CITY OF ALBUQUERQUE

Re: SAFStor Storage
Not addressed- SW corner of Central Ave and 106th St
UPC 100805638540210405
Request for Certificate of Occupancy- 30 Day Temp
Transportation Development Final Inspection
Engineer's Stamp dated 1-13-22 (L08-D013)
Certification dated 11-16-23

SP1. SITE PLAN FOR BUILDING PERMIT
SP2. ROADWAY X-SECTION EXHIBIT
GR1. GRADING AND DRAINAGE PLAN
MU1. MASTER UTILITY PLAN
DET-1. DETAIL SHEET
DET-2. DETAIL SHEET
LS-1. LANDSCAPING PLAN
B1. BUILDING ELEVATIONS
B2. BUILDING ELEVATIONS
B3. BUILDING ELEVATIONS
B4. BUILDING ELEVATIONS

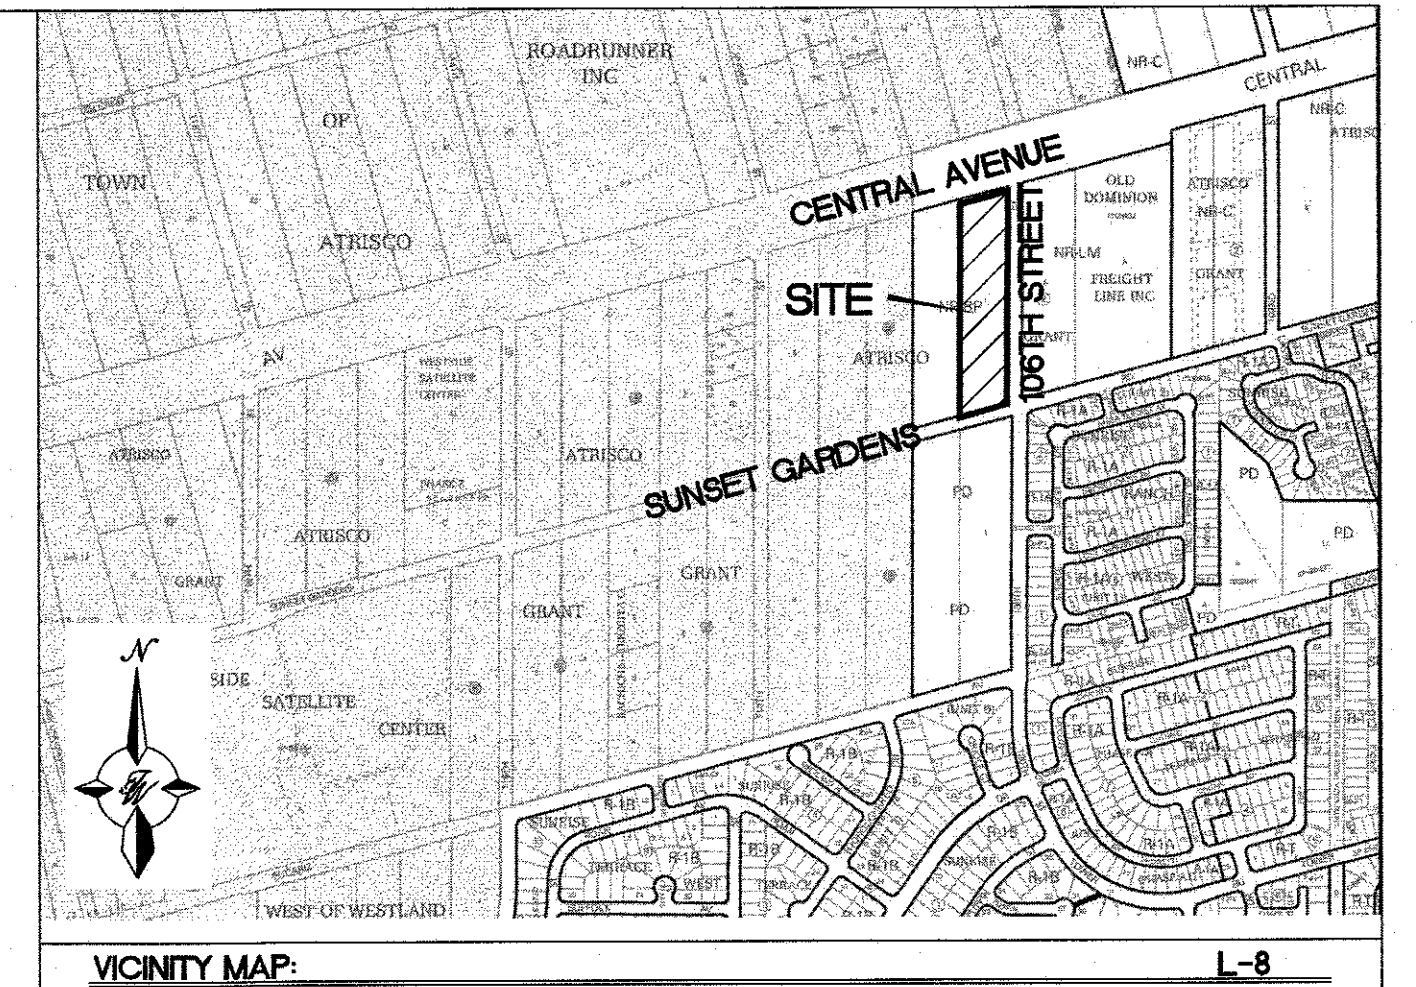
1. Access from an open (constructed and not barricaded) public street that can be used by motorists, pedestrians and cyclists is to be provided.
2. Complete the Transportation related items on the provided punchlist.
3. The handicap van aisle striping was only 5' wide, whereas, it is to be 8' wide.
